Winnemucca Lot Line Adjustment, VR-18-007

Please accept the following comments from El Paso County Public Health regarding the lot line vacation/replat project referenced above:

LOT 92 AND 93, UTE PASS SUMMER HOMES COMPANY SUB. NO. 1 AMENDED PLAT

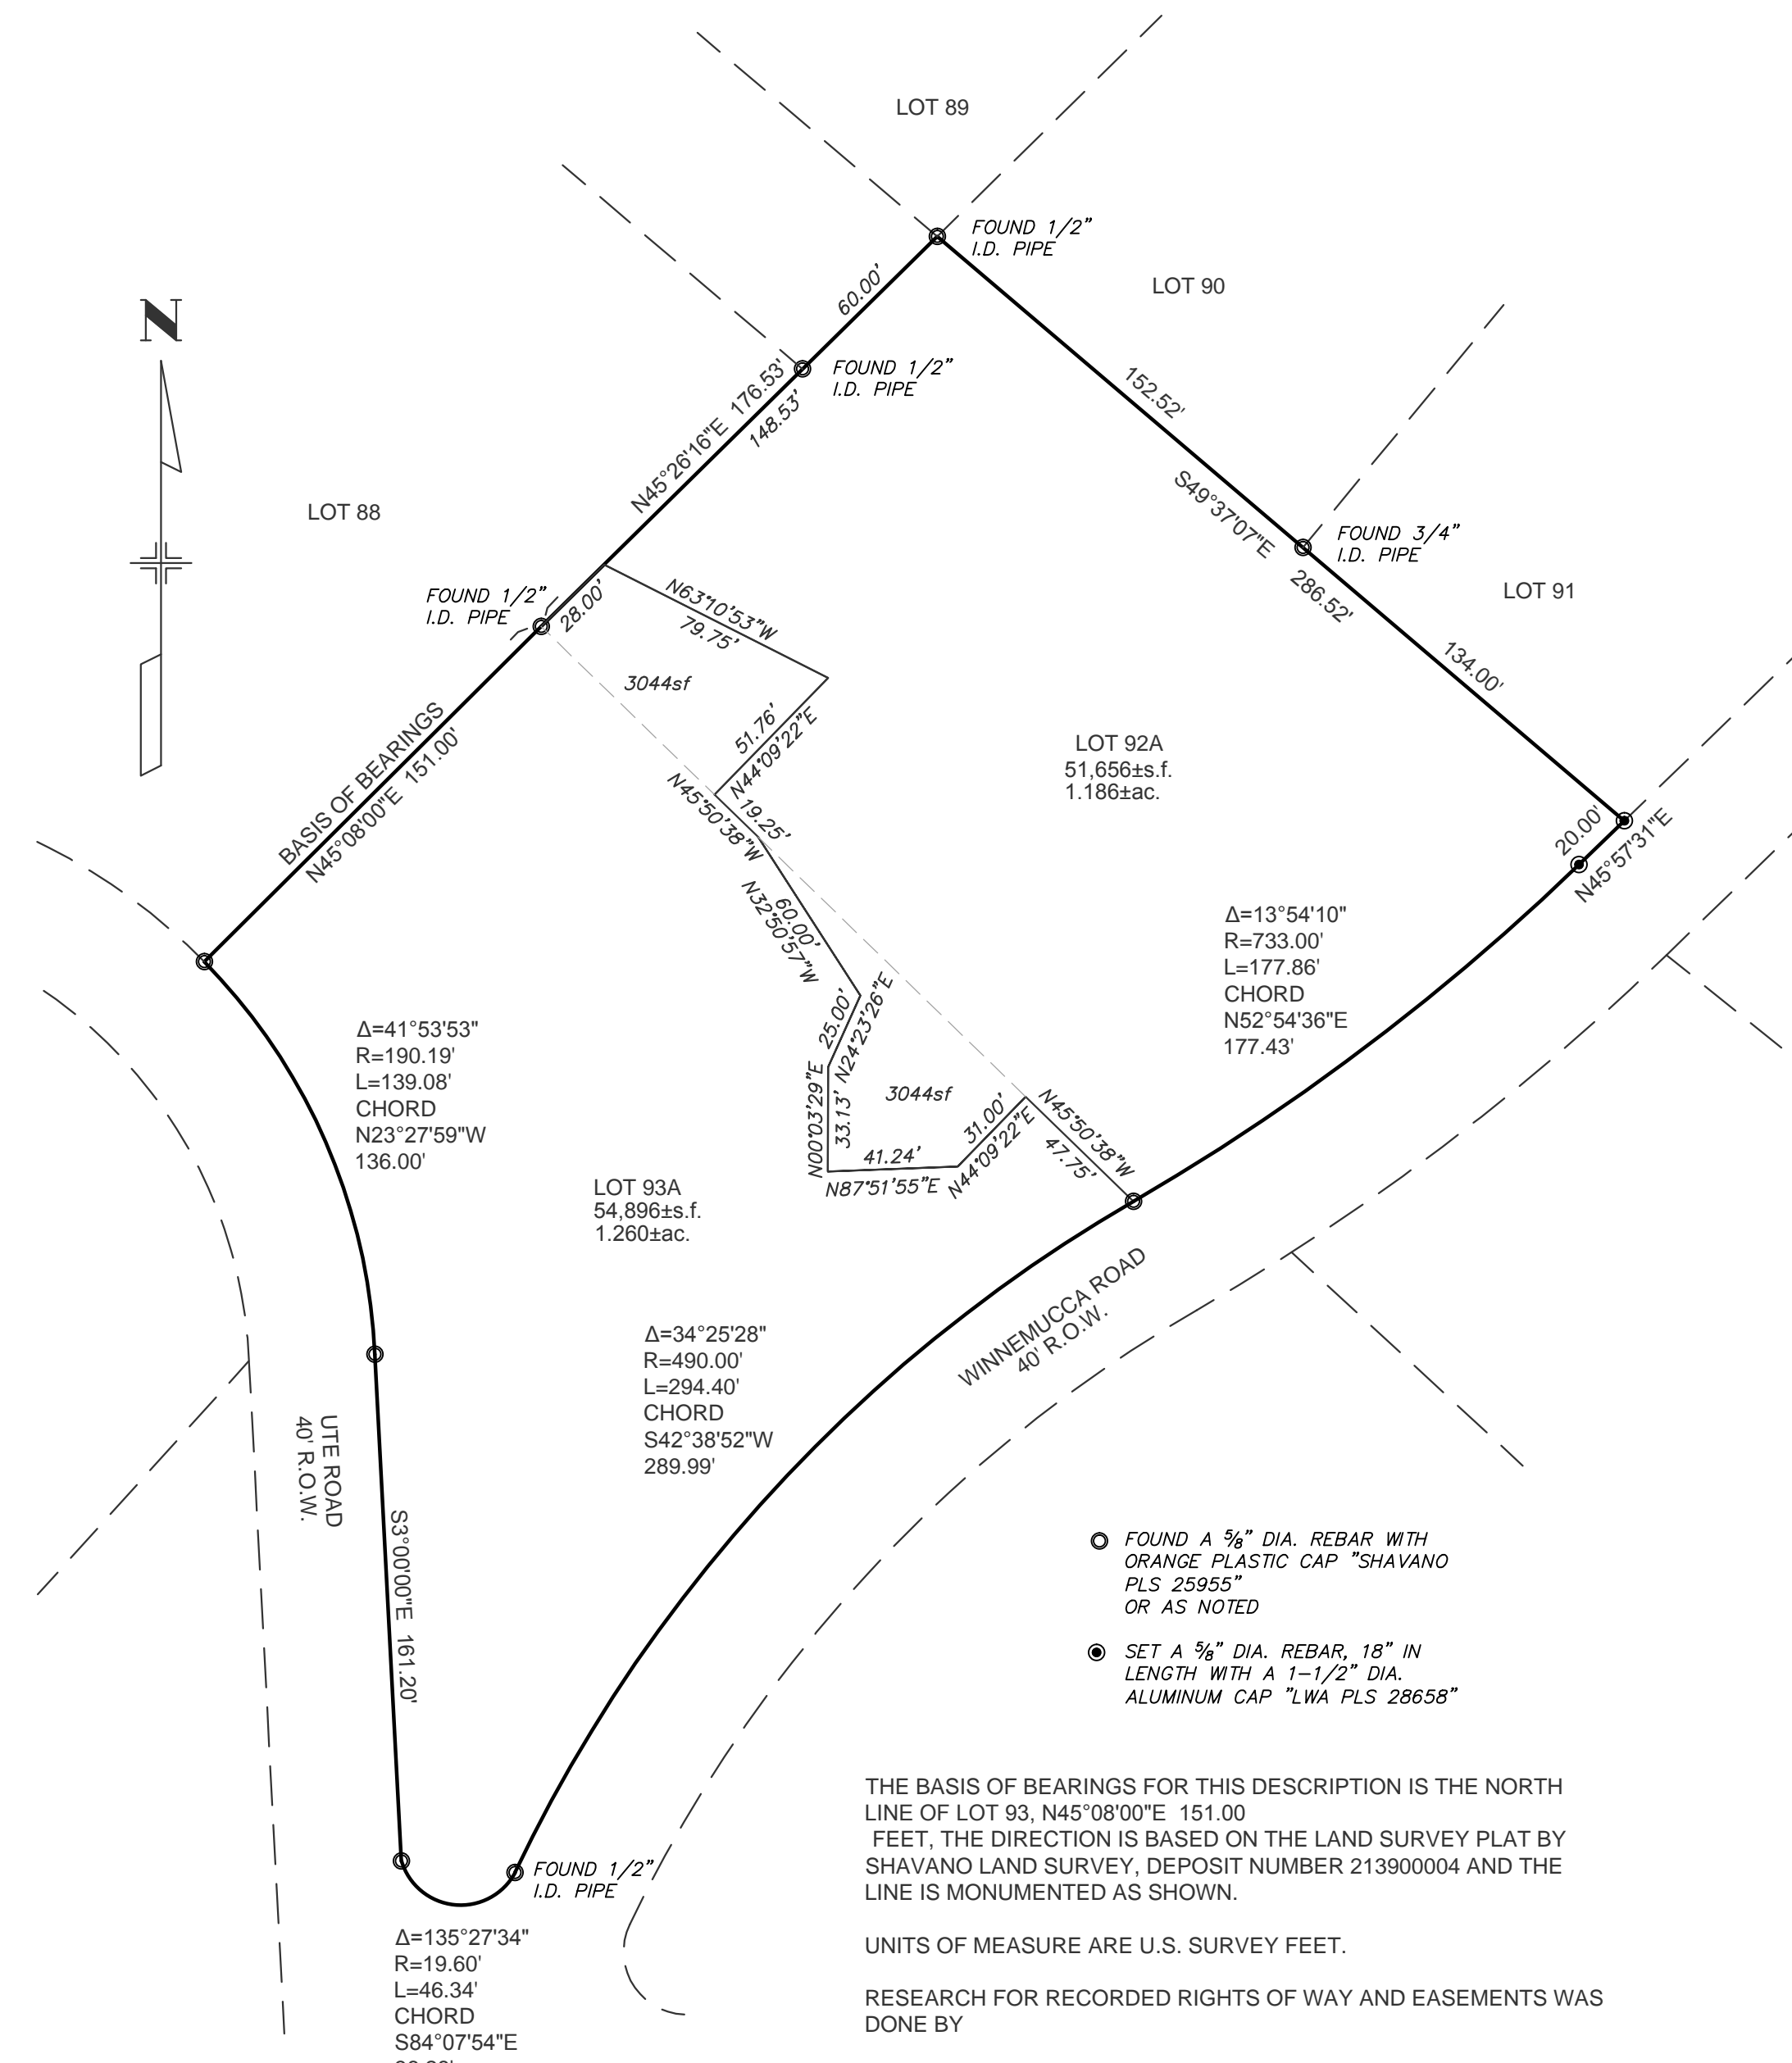
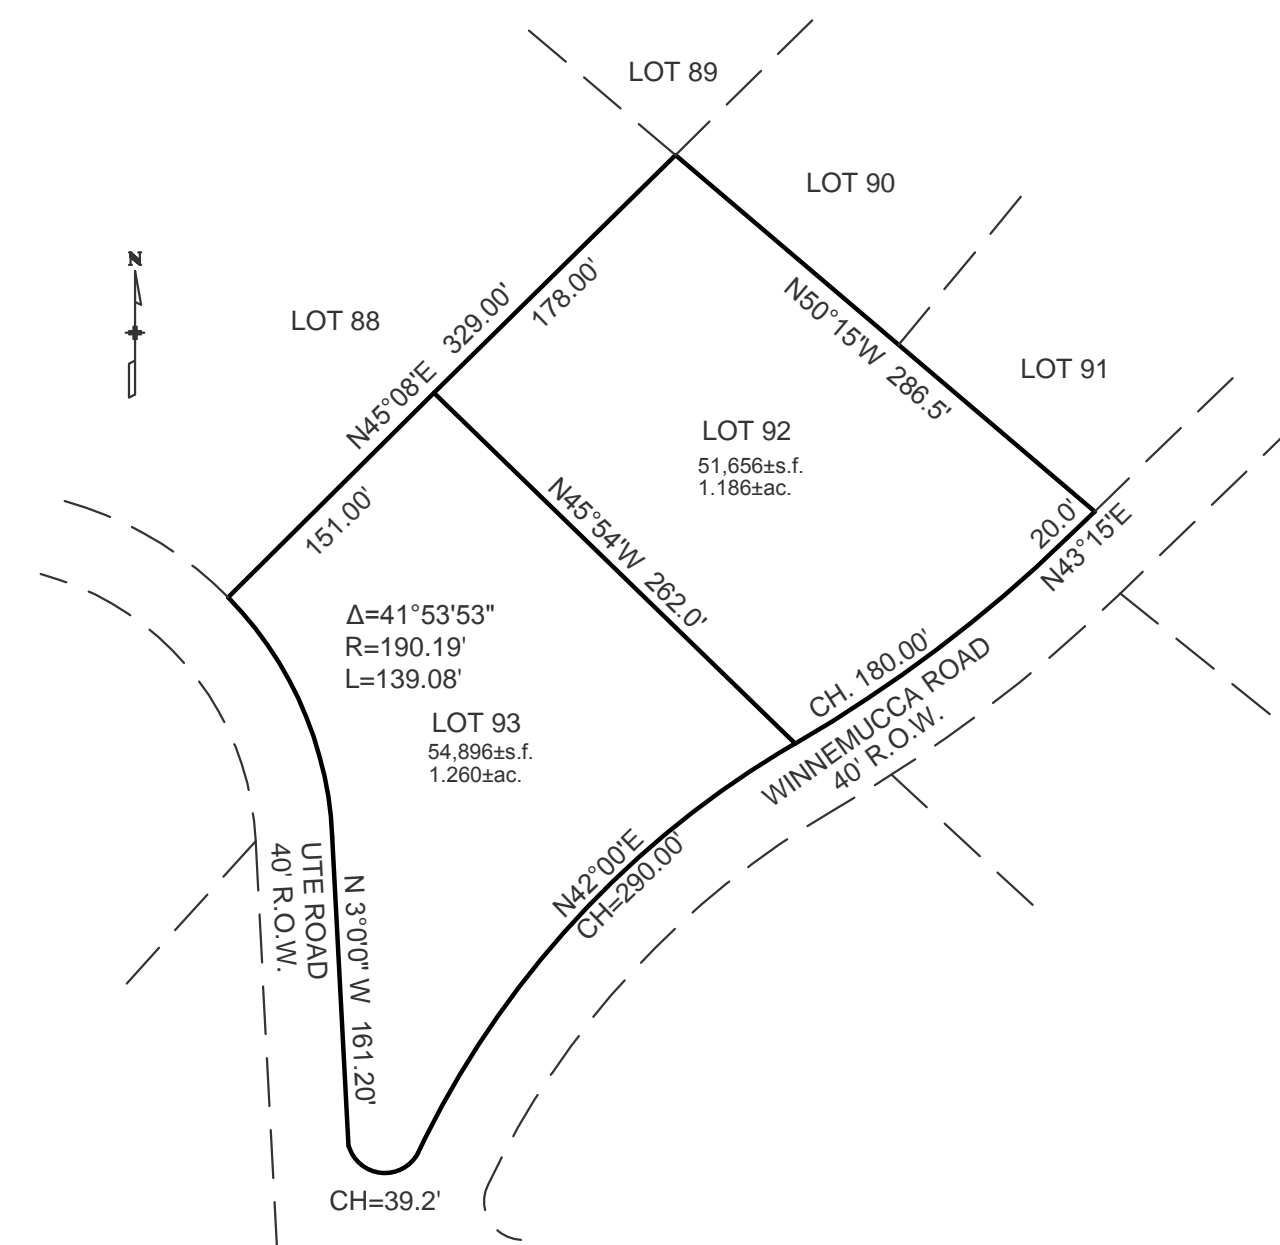
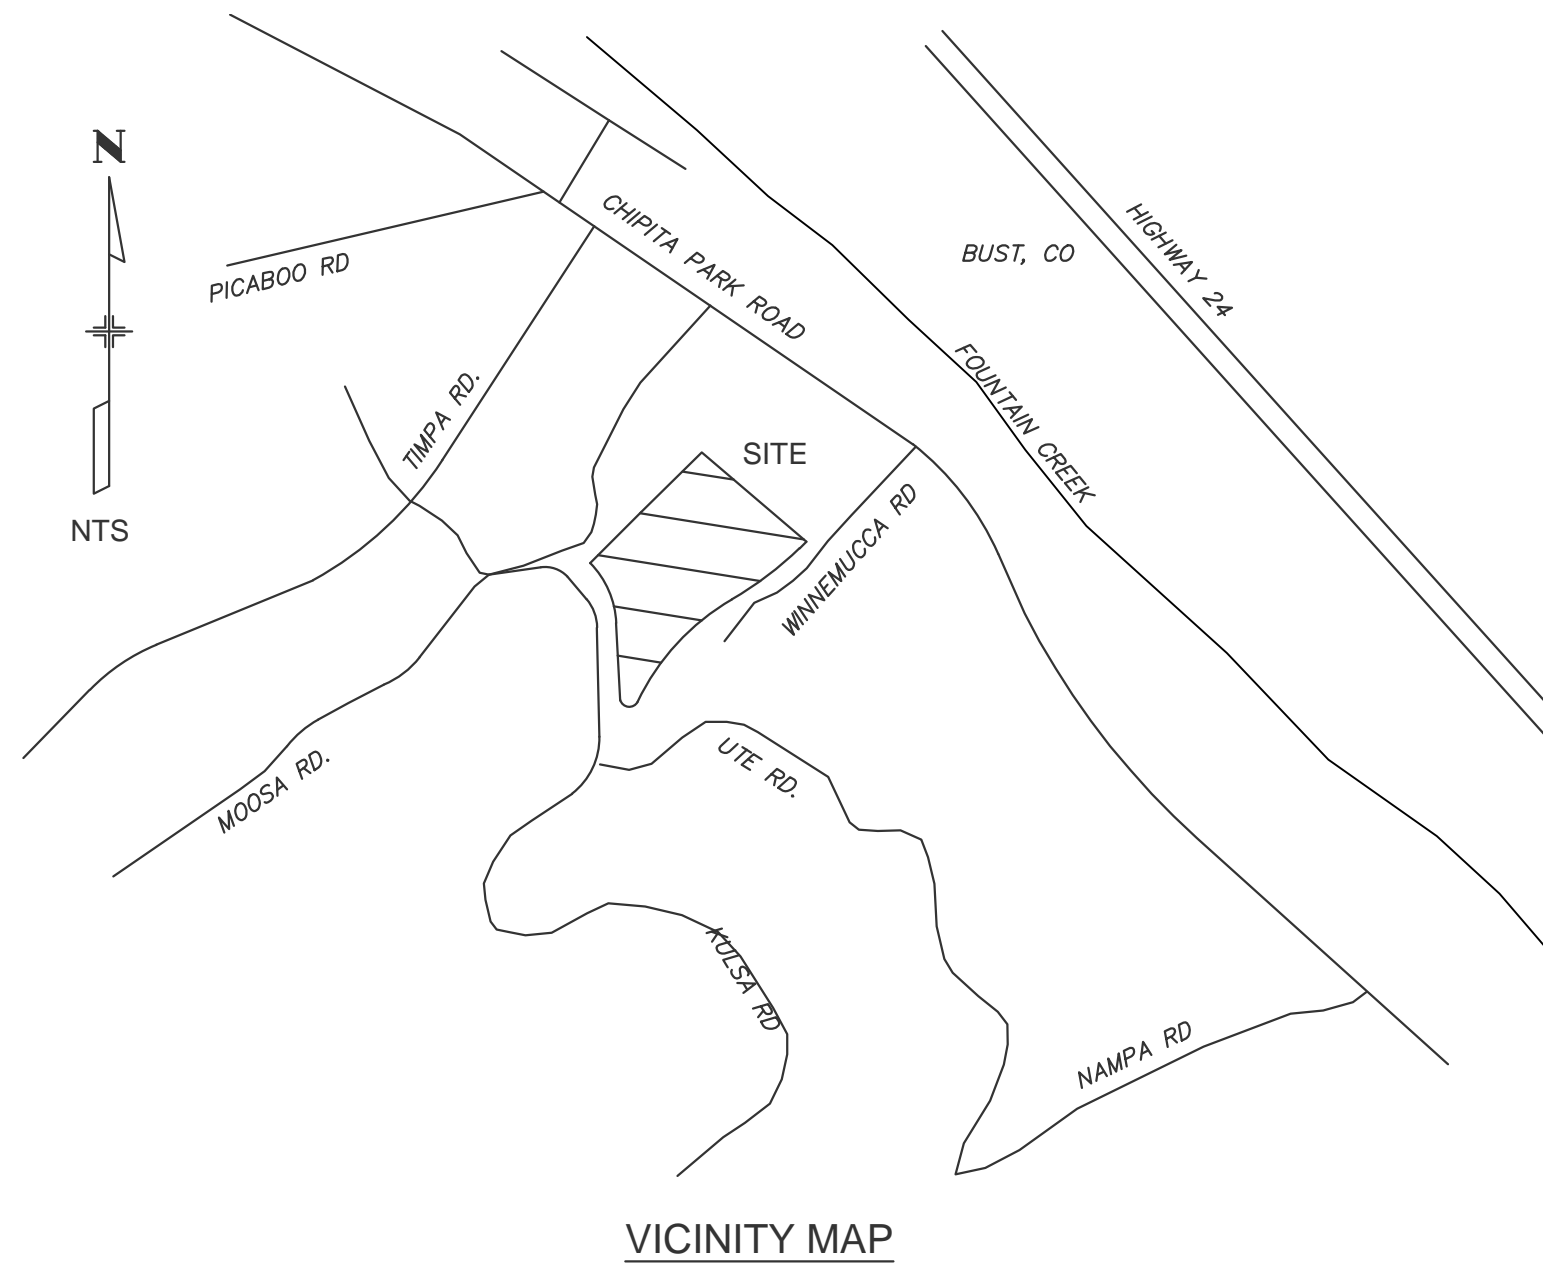
The El Paso County Public Health drawings of the two OWTS's are not to scale; therefore, it is advised that the exact location of the OWTS components be verified in the field to assure all components will be on the same lot as the structure it serves should the lot line vacation/replat be approved. There must be adequate lot area, also known as the secondary site, for the repair or the replacement of the soil treatment area (STA) should it ever fail in the future. Although there is an access easement agreement planned, the existing STA sites and the secondary sites shall be on the same lot as the structure they serve, and not within an easement.
